SANDSTONE PRECINCT

DESIGN REVIEW PANEL - ADVICE 10

4 October 2019

EDUCATION BUILDING

Column setting out

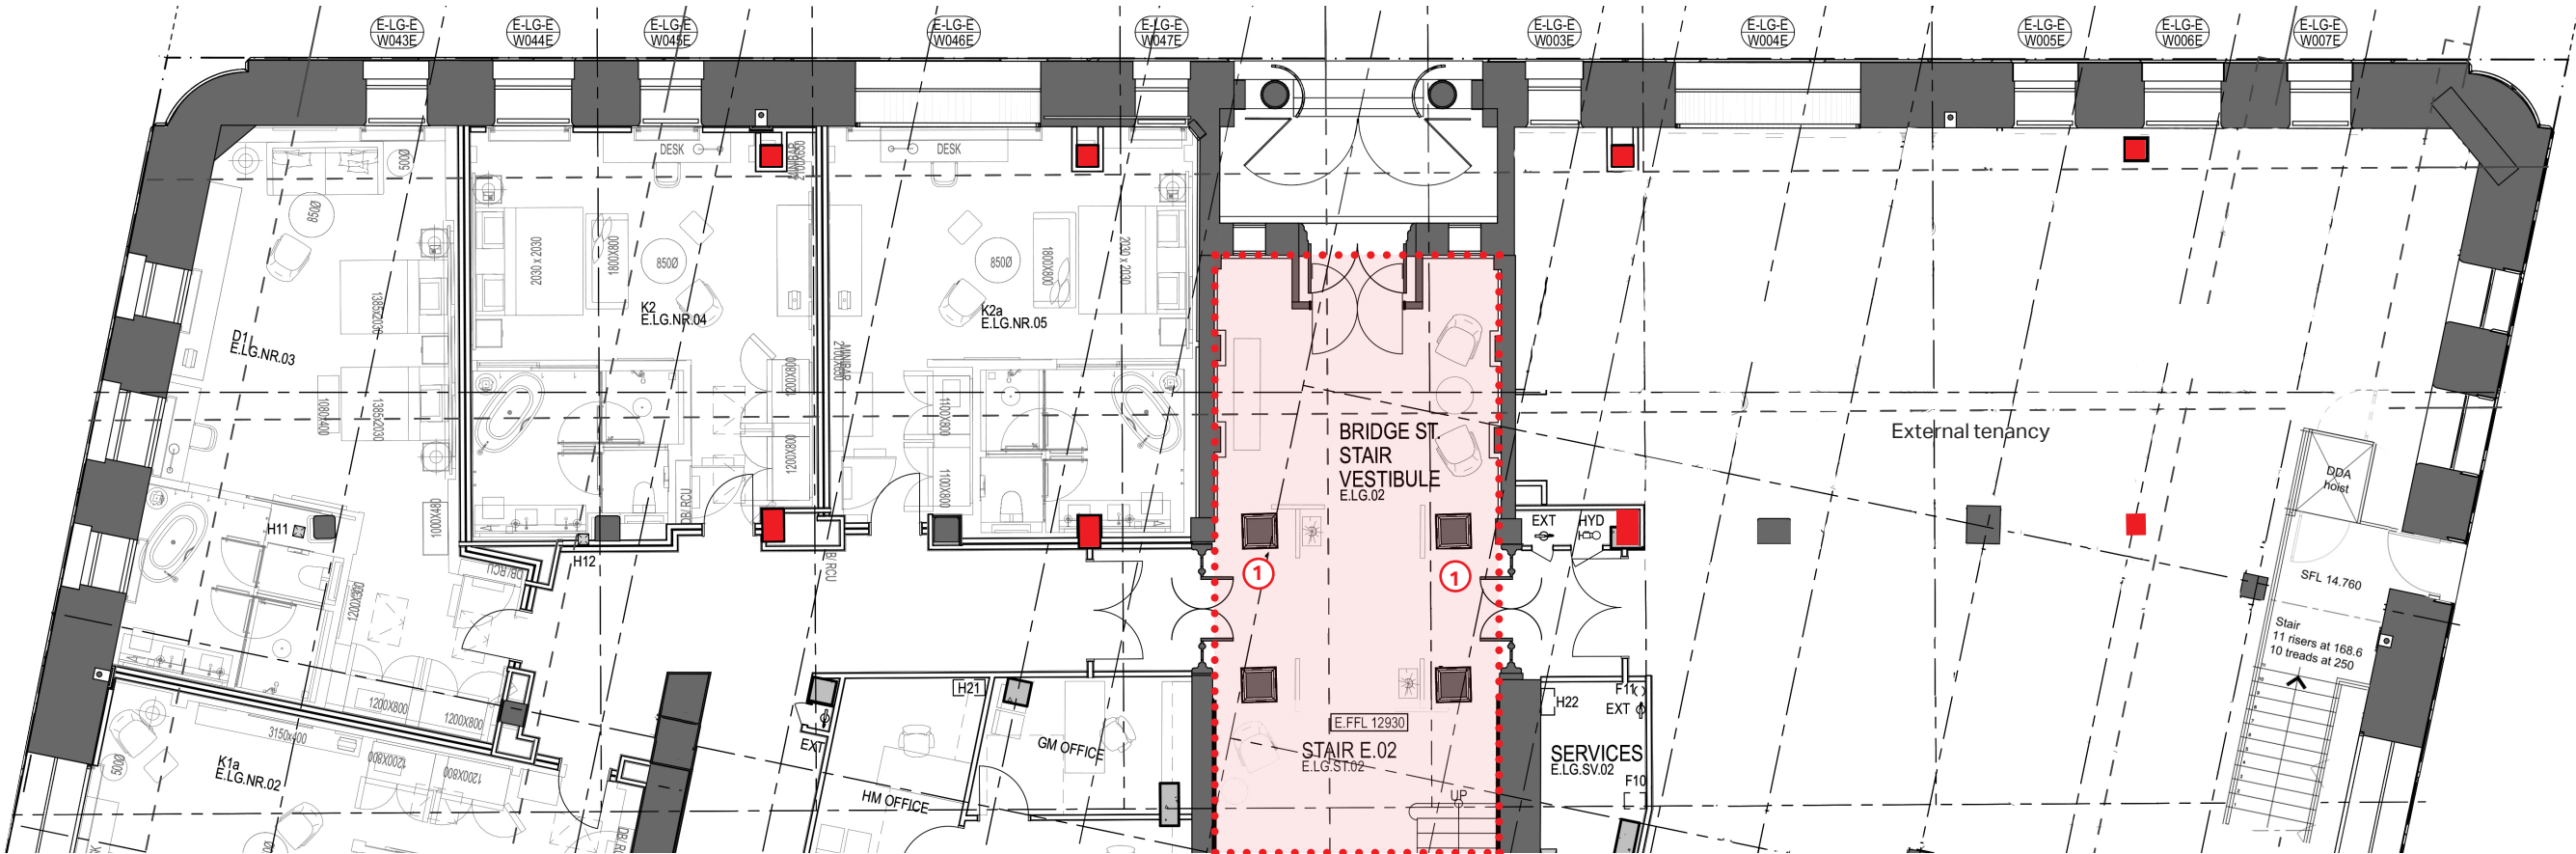
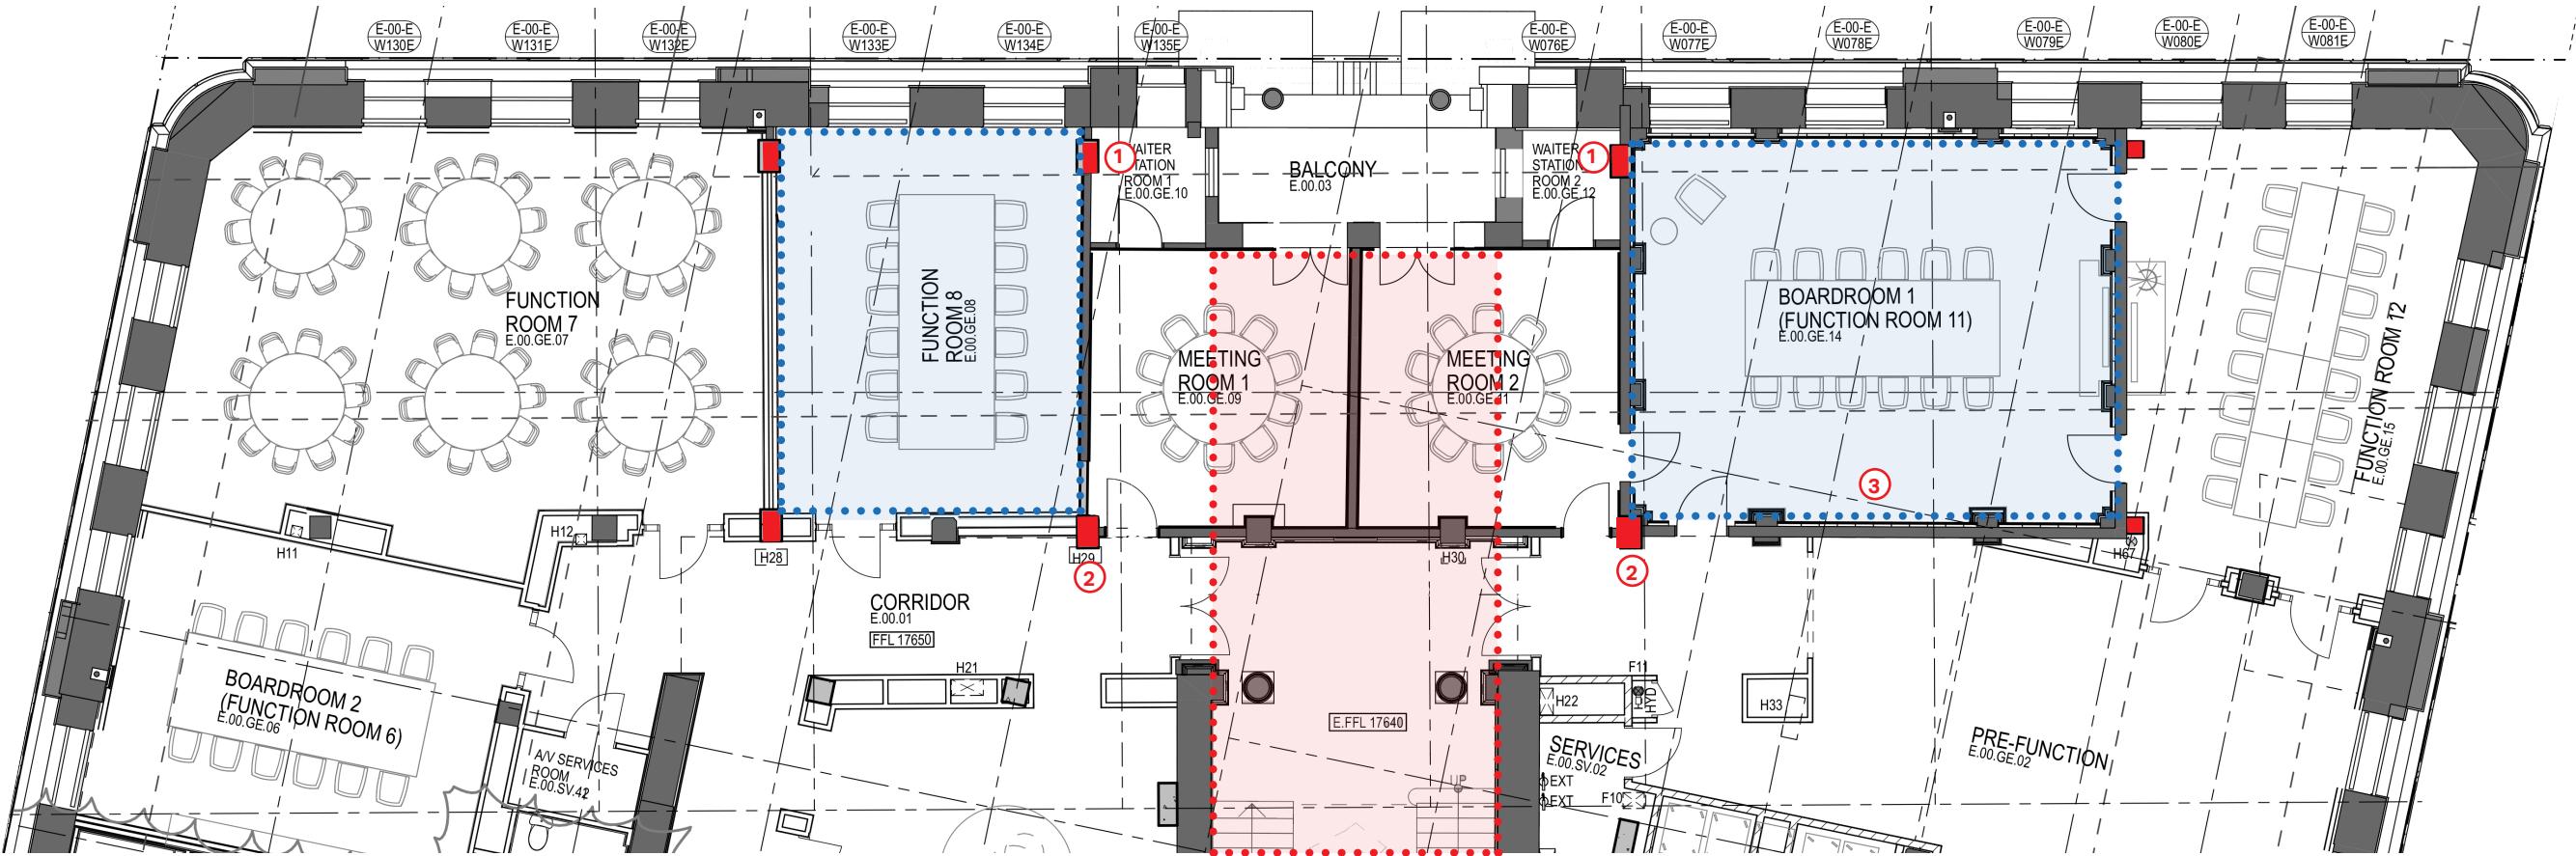
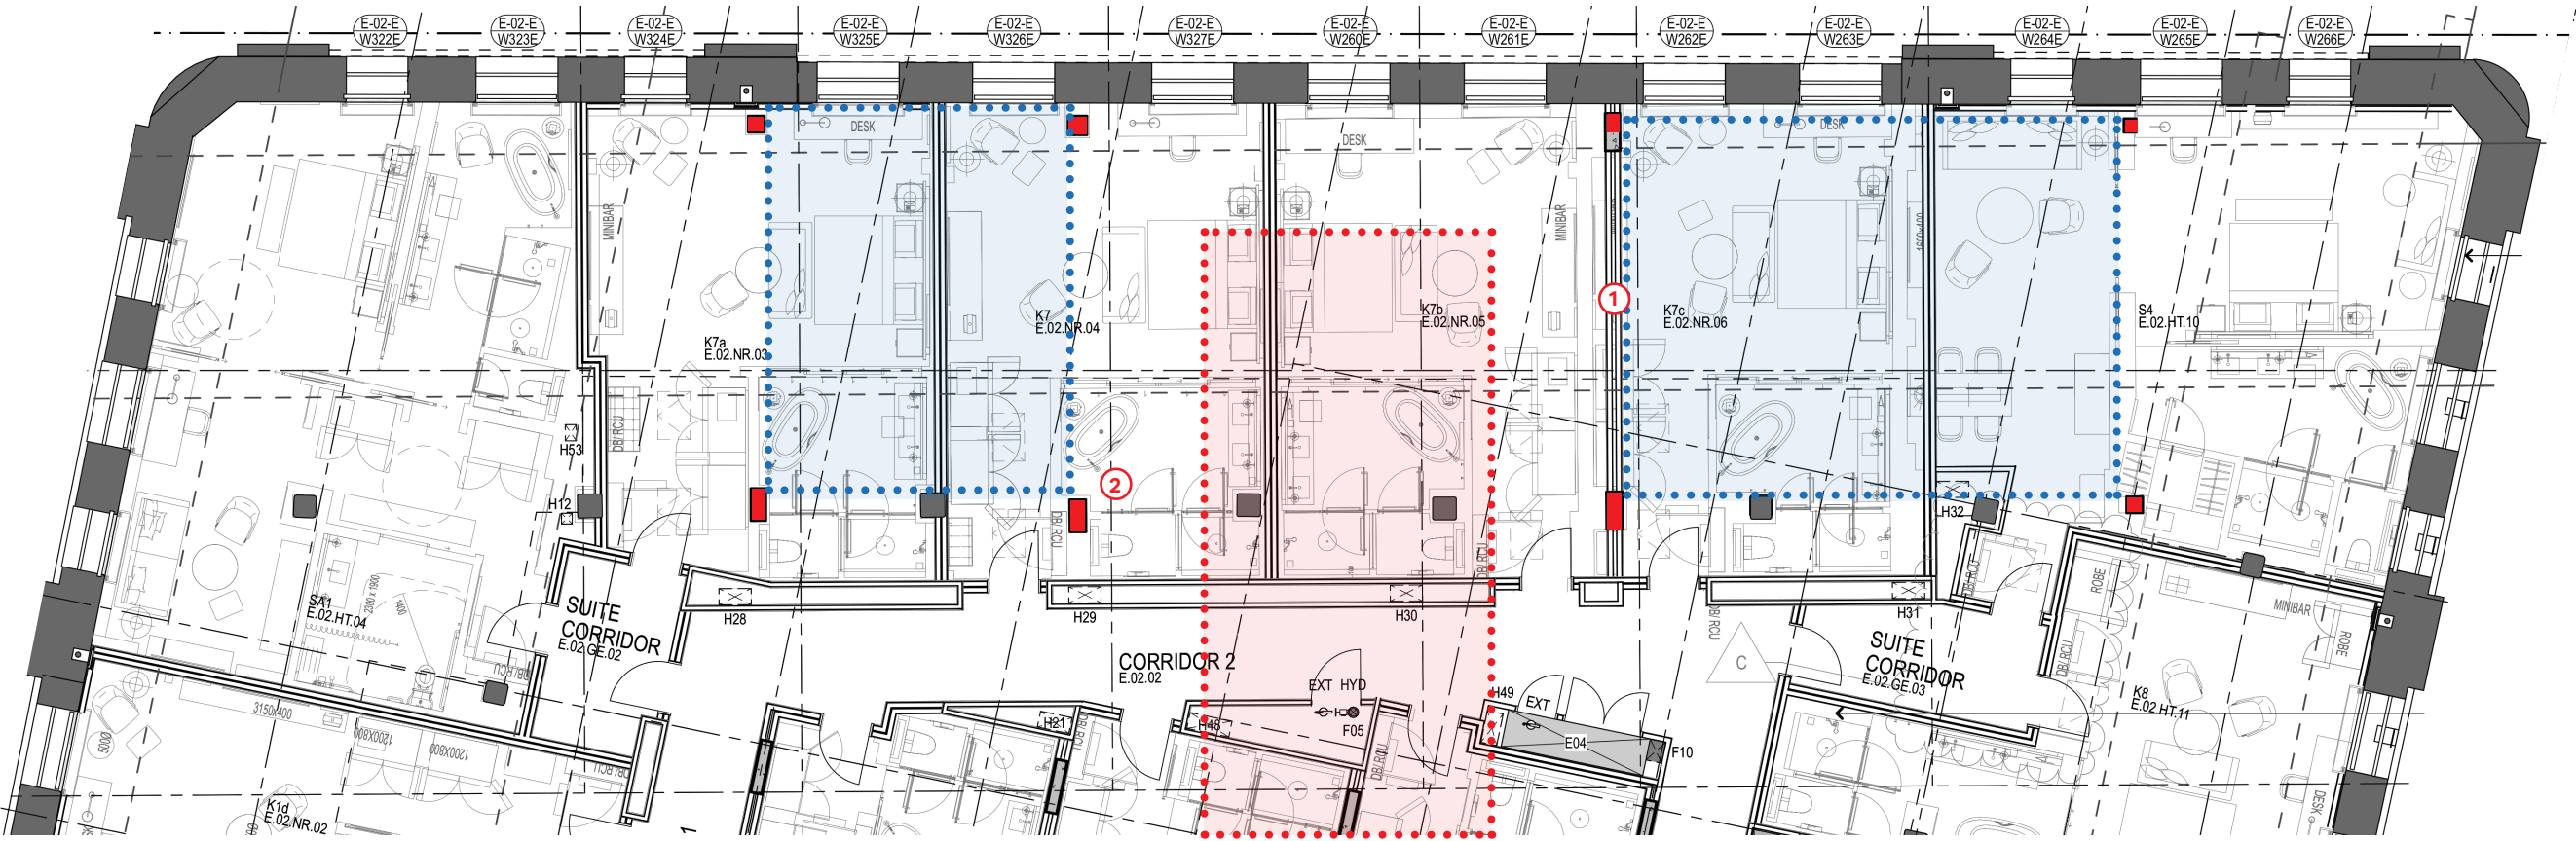
The Panel notes the introduction of columns through the building to support the pool on Level 5 and believes their placement has been considered and is appropriate. The Panel understands the general strategy of incorporating these into walls or furniture items and requests further detail of their treatment within the spaces on each level when this is developed.

Proposed relocation of door: Gym entrance

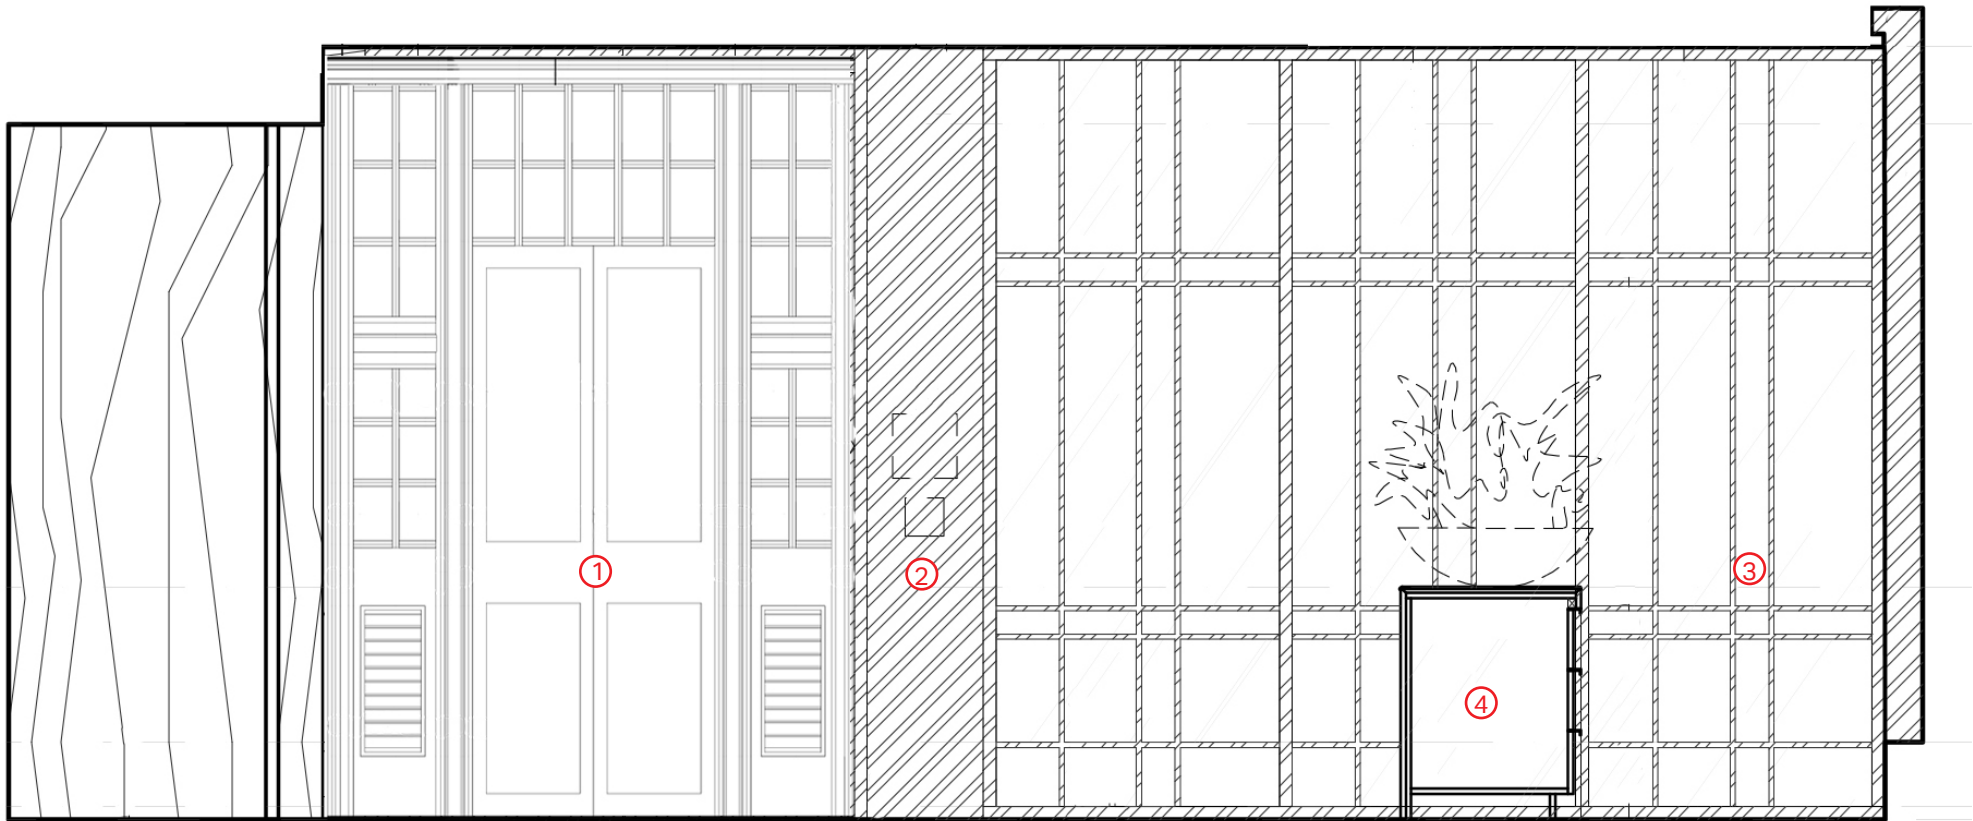
The Panel accepts the strategy to modify the heritage door to the Gym on Level 5 to allow a contiguous floor level to the gym. It notes that this can be achieved by the removal of two rows of glass panels and the changing of the proportions of the glazed panels, which match the height of the level change.

The planning changes and the reuse and relocation of the heritage door is supported.
